WELWYN HATFIELD COUNCIL – DEVELOPMENT CONTROL
DELEGATED REPORT

APPLICATION No:	N6/2010/2467/FP
------------------------	------------------------

This application seeks planning permission for the erection of a new County Library Services building.

Landscape plan

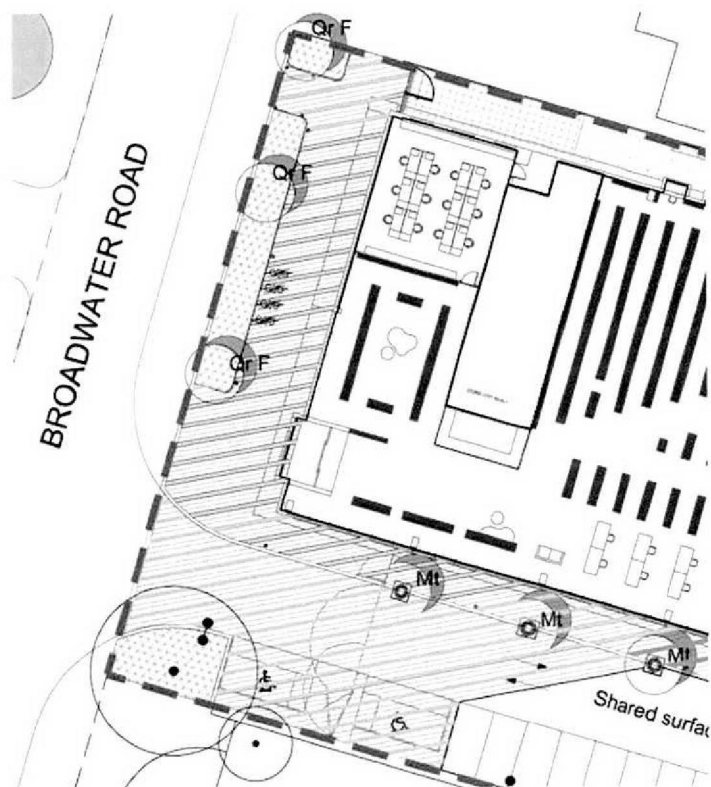
With regard to the soft landscaping proposed, clarification on the boundary treatment, height of the gabion wall, mounds on site and the landscaping along the Broadwater Road frontage is required.
